November 22, 2019

RE: *Green Mountain Falls County Documents Review Comments and Redlines*

Thank you for the comments on November 18, 2019 for the above-mentioned project. In an effort to address your comments concisely and simplify your review process, we have summarized your comments and our responses below.

GRADING PLAN
SHEET 5 OF 14

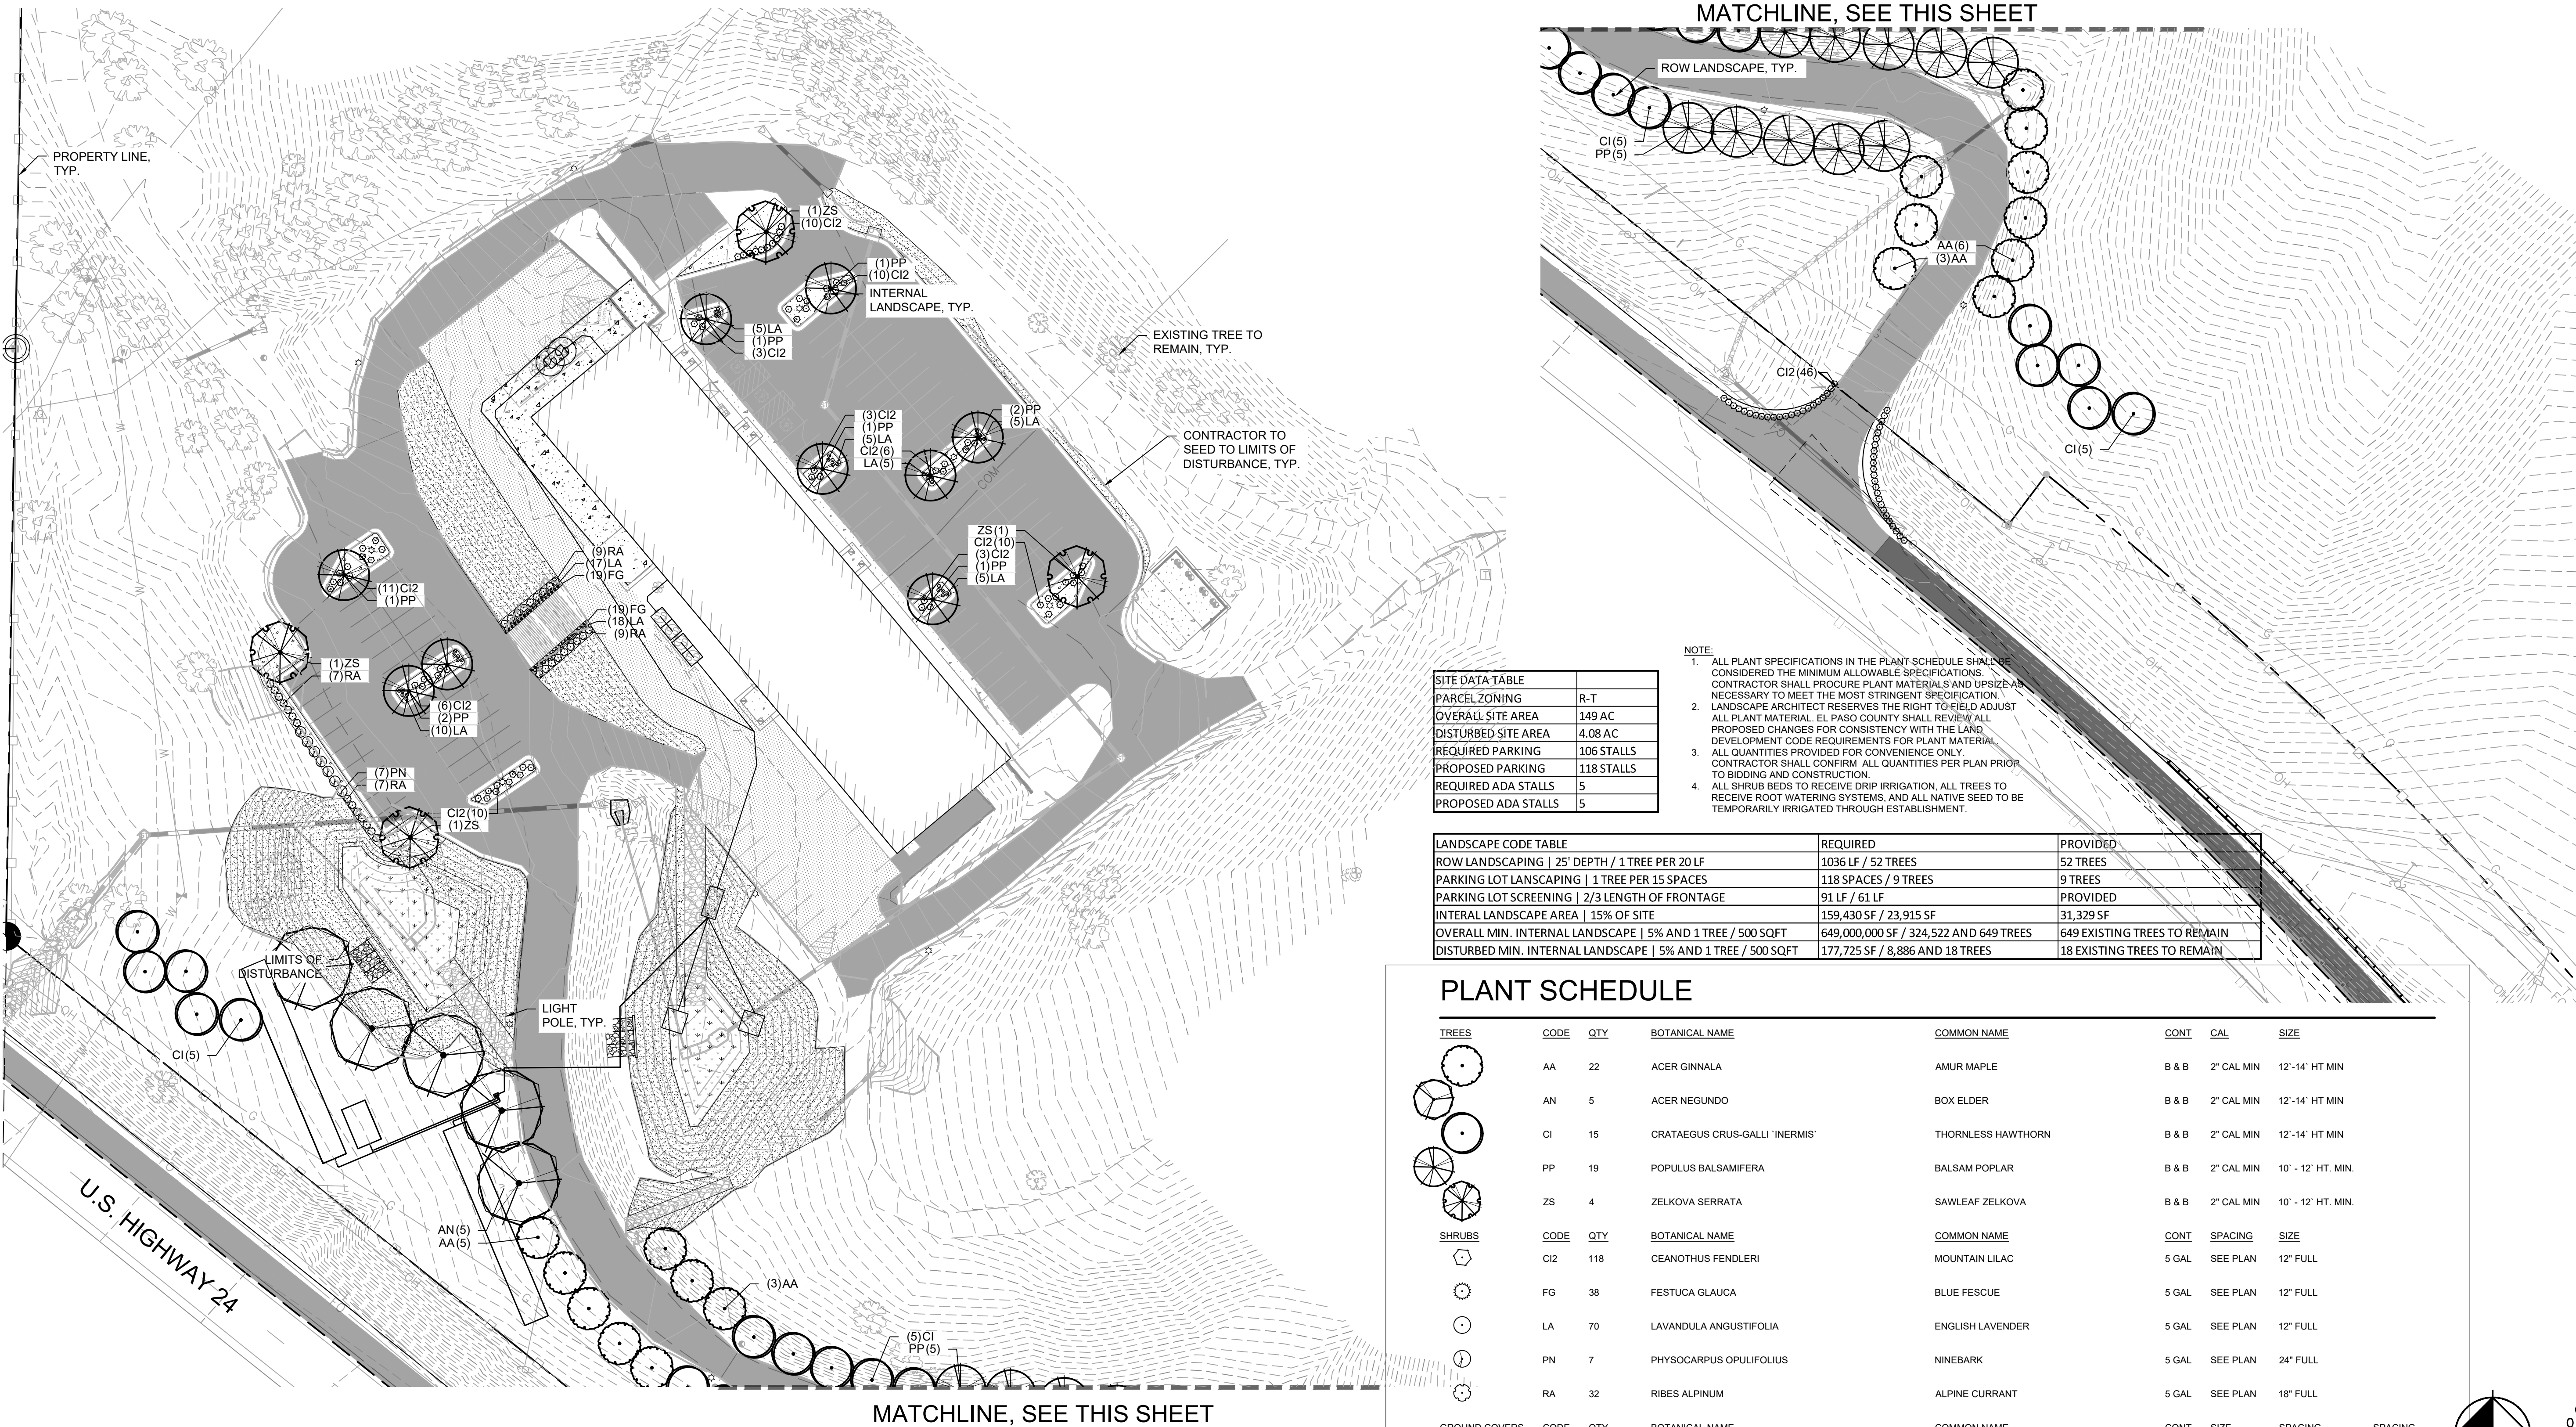
1. Is the sidewalk to the north of the building flush with parking or is there a curb transition? If no curb transition, wheel stops might be needed for the spaces that front the sidewalk along the building to preserve the accessible path of travel along the sidewalk from potential vehicle overhang.

Response: Wheel stops have been added to the NW and NE stalls bordering ADA routes.
2. If there is no objection to the proposed changes to the Detention Maintenance Agreement, please accept them and submit a clean copy for final review.

LEGACY CHURCH - GREEN MOUNTAIN FALLS, CO

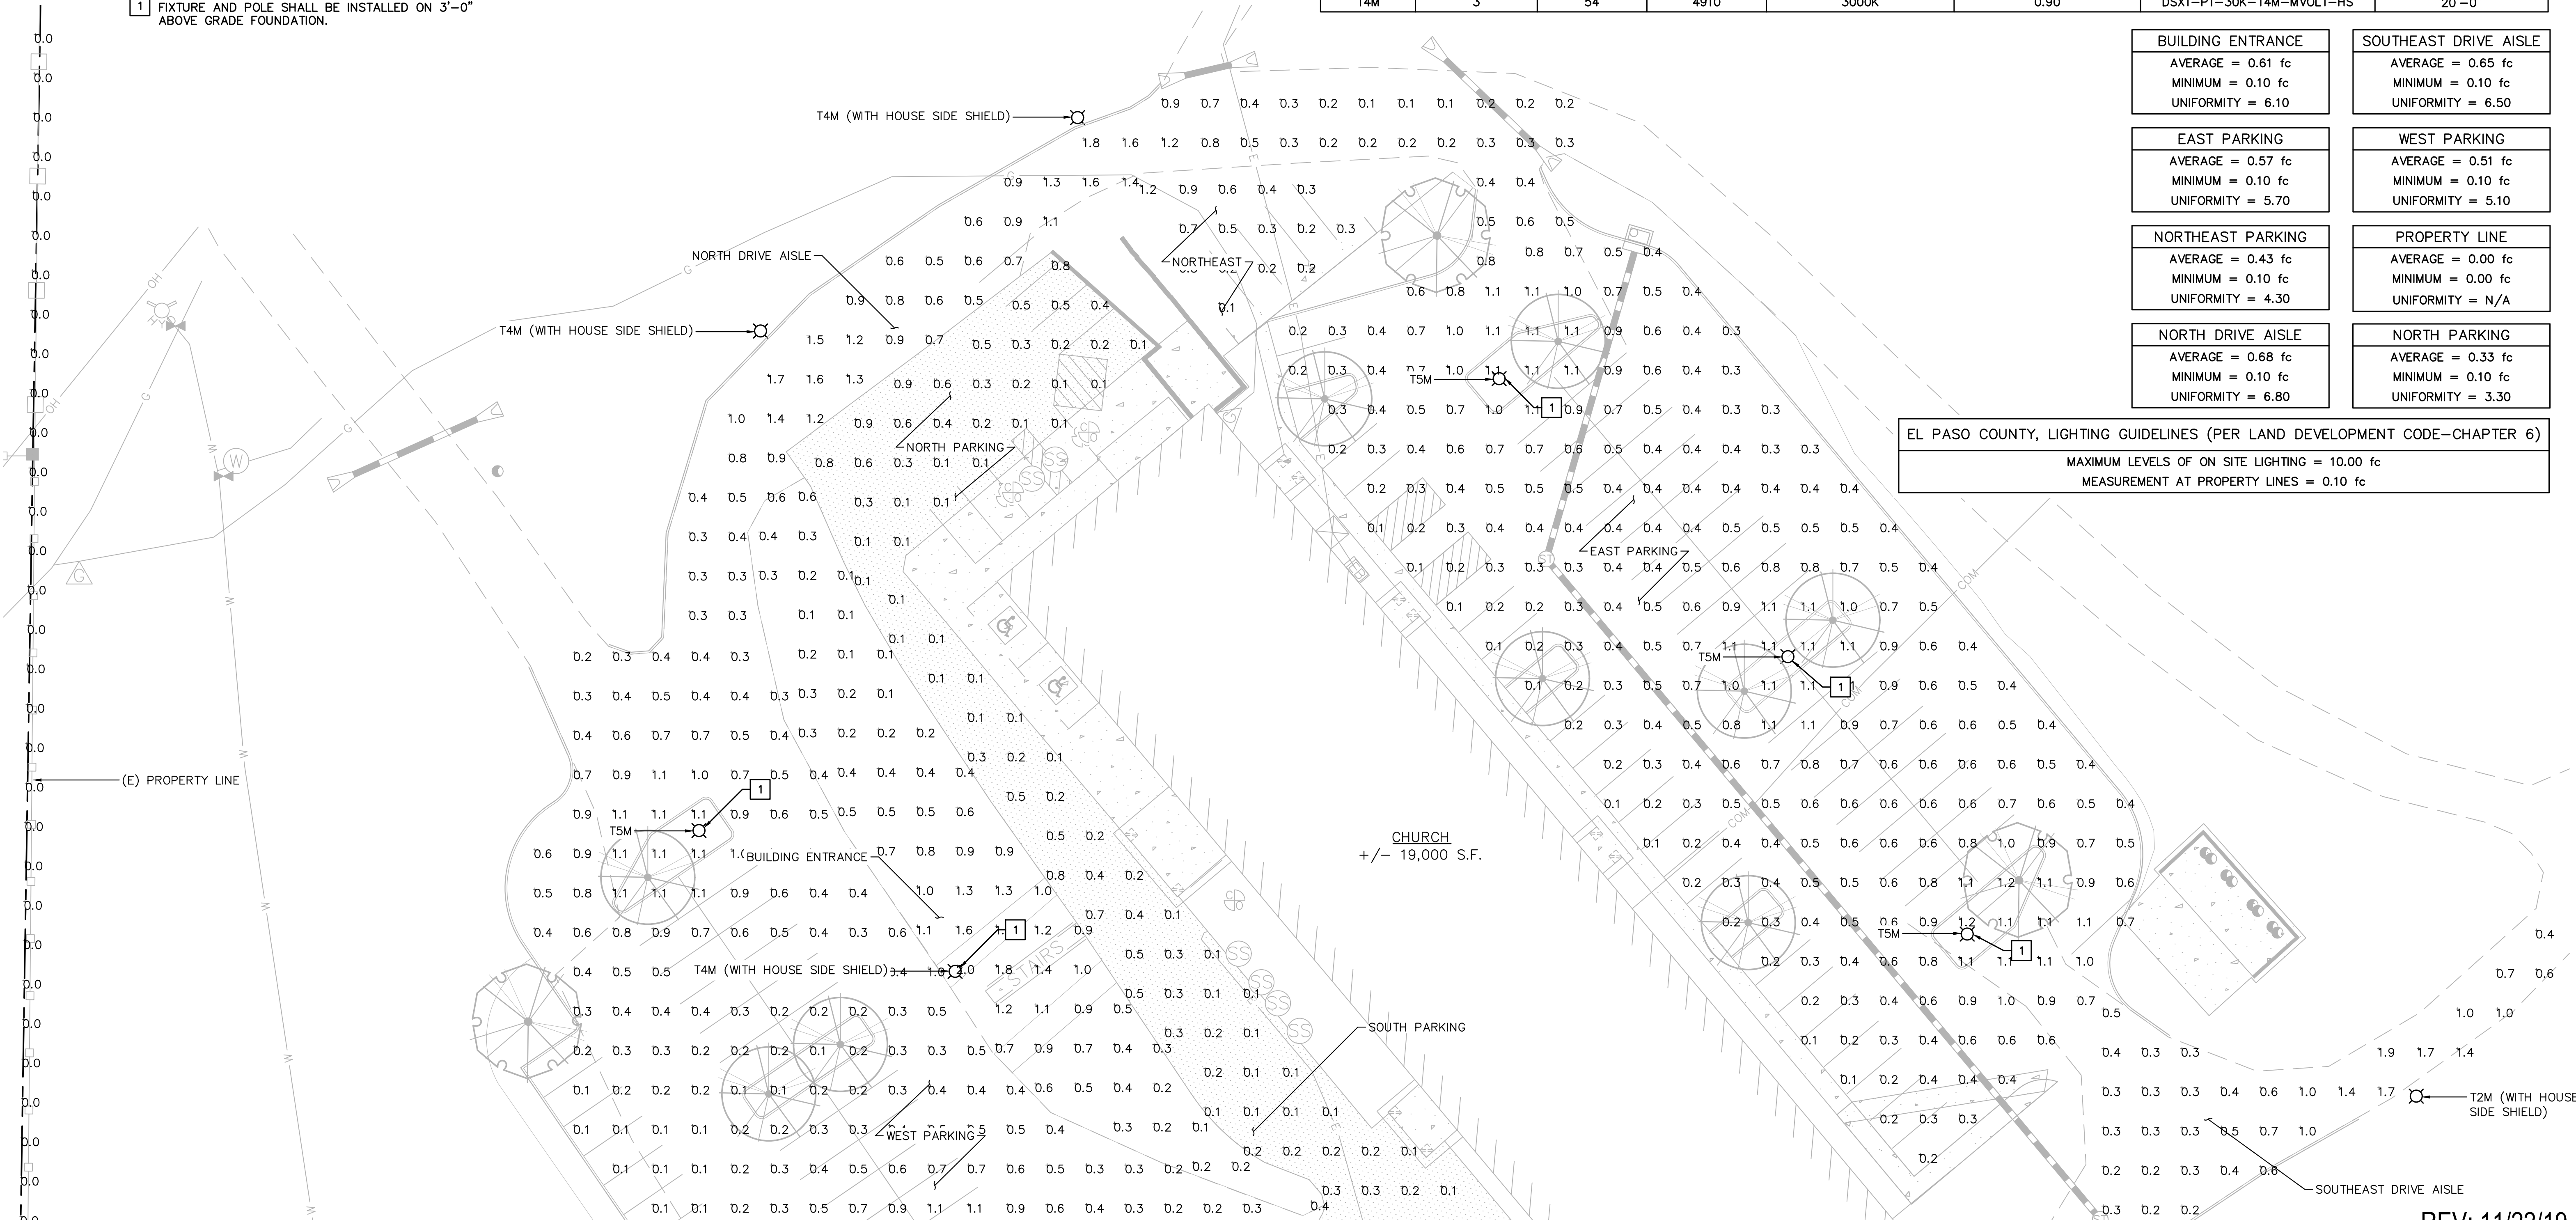
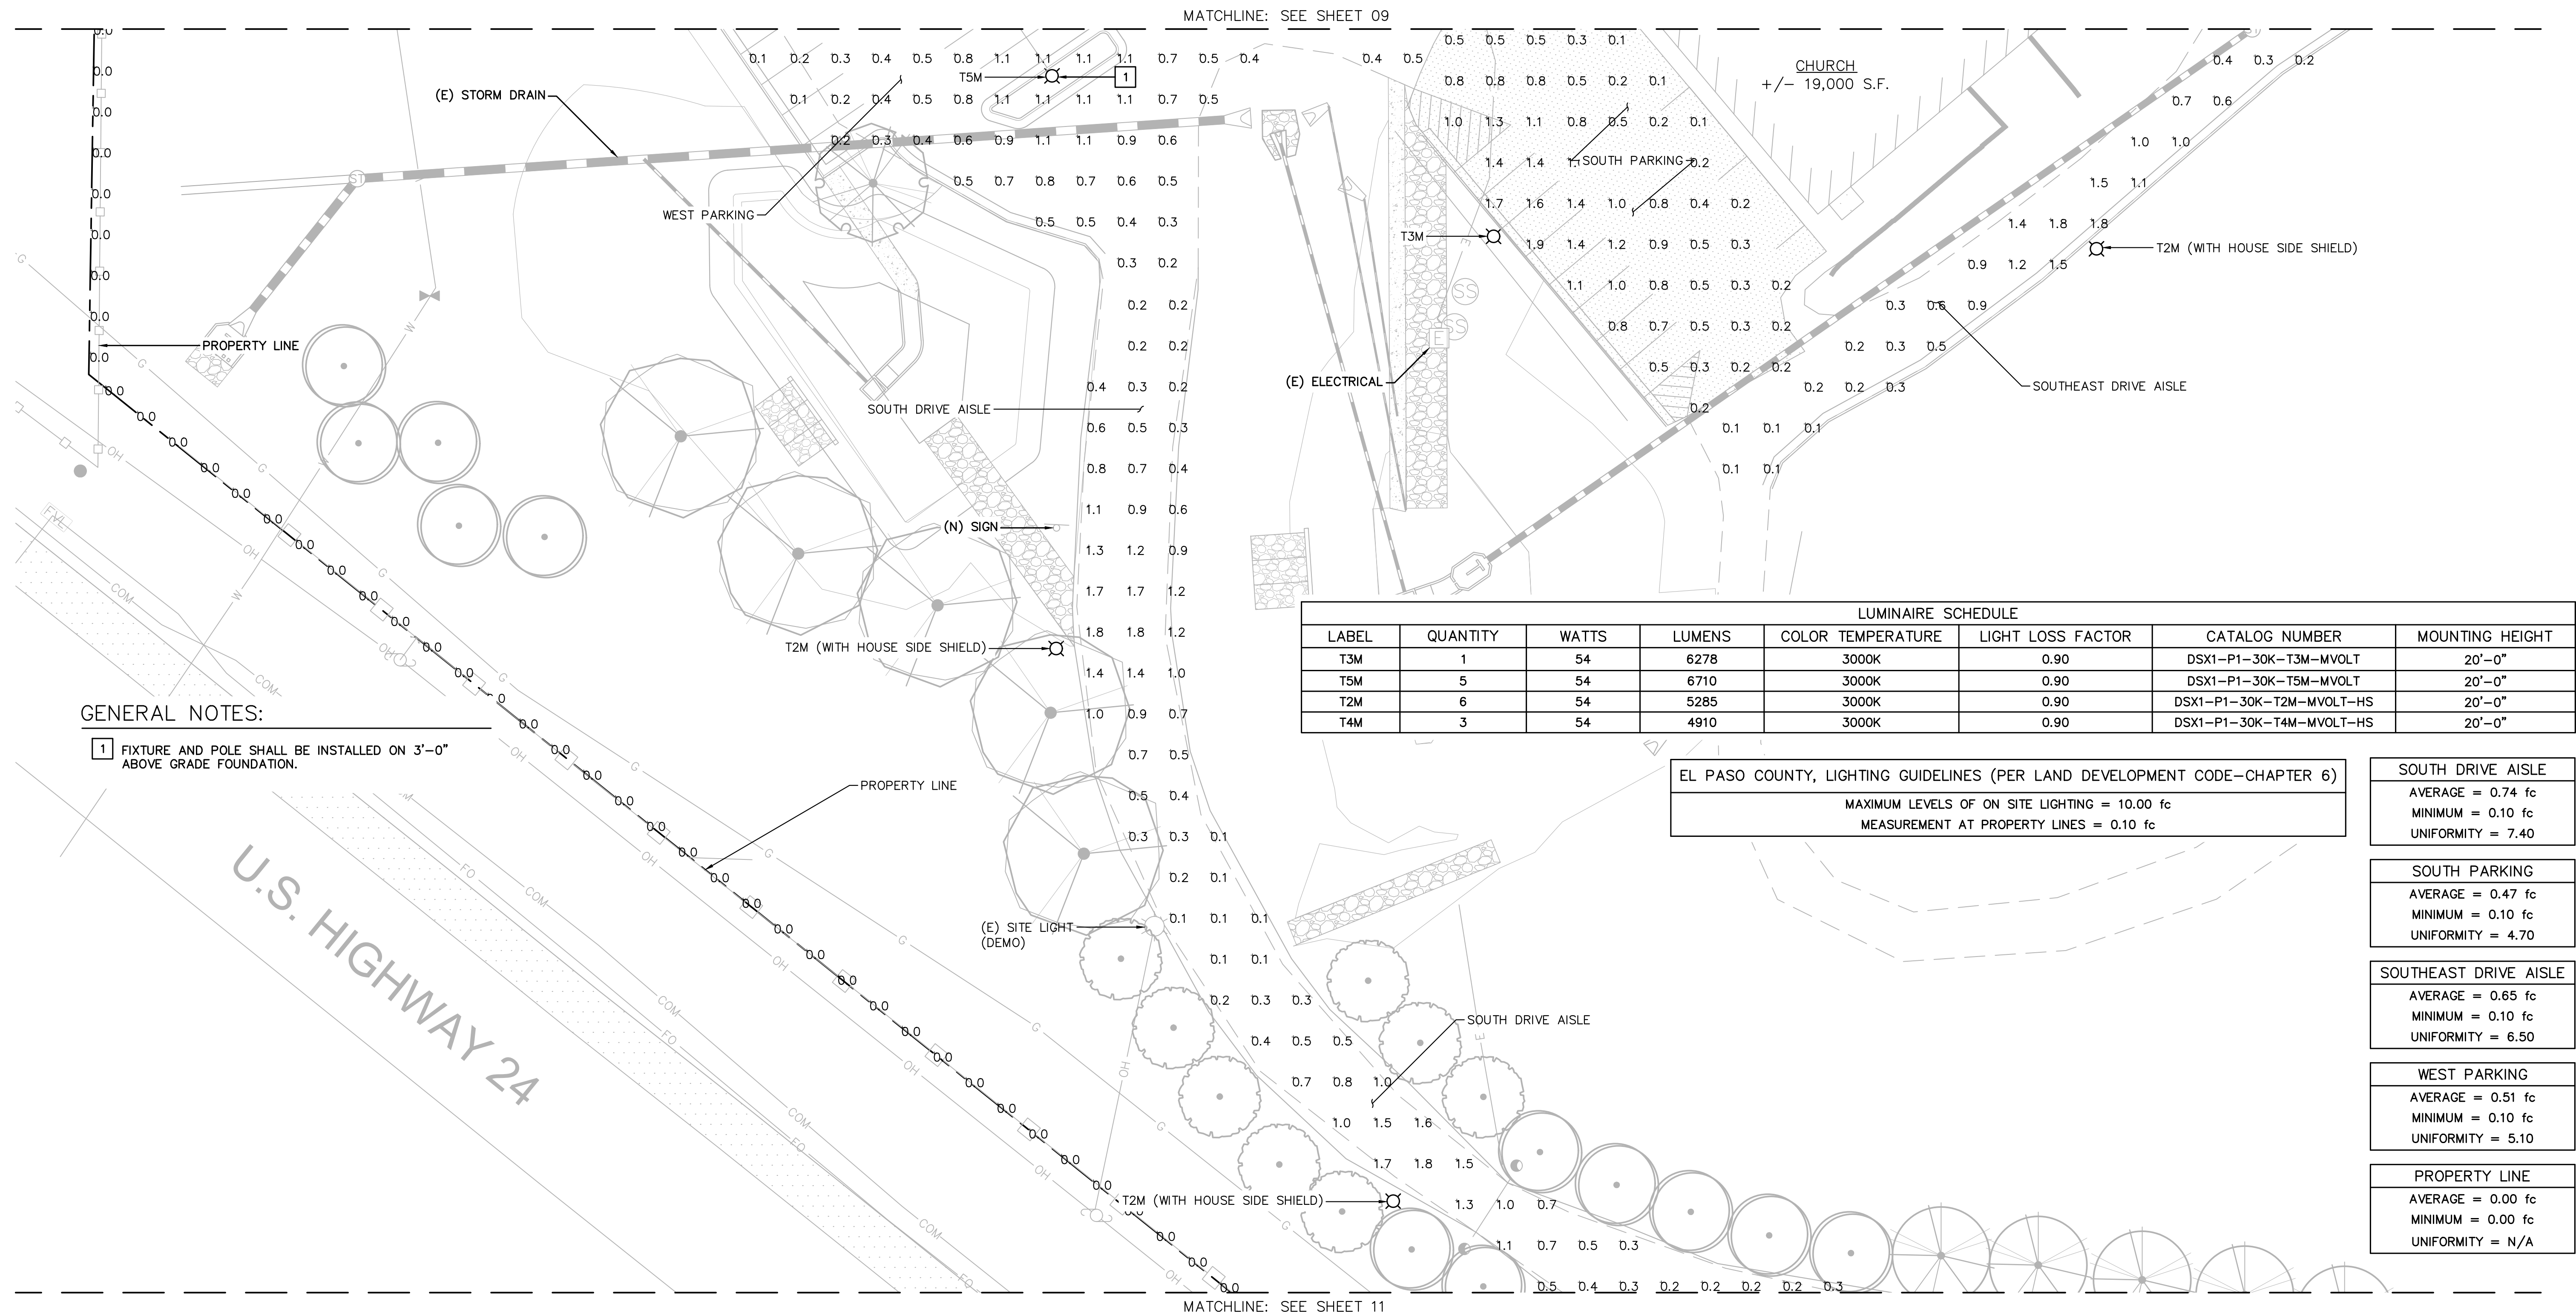
Response: A clean copy of this document has been provided in this submittal.
3. Please review the lighting plan with the landscape plan to ensure there are no tree/light conflicts. There appear to be trees in close proximity to light poles. The trees are required to be on planting islands, so the lighting plan may need to be revised to move light poles to the exterior edges of parking lot. Note to avoid conflicts there should be 15-20 feet between each light pole and tree center. We want to avoid a situation where trees must be pruned in an unsightly manner or removed in the future due to shading out site lighting.

Response: Light poles and trees have been relocated to provide at least 15' of clearance.
4. Submit confirmation that the State Non-Jurisdictional Water Impound Structure application form has been submitted to the state.
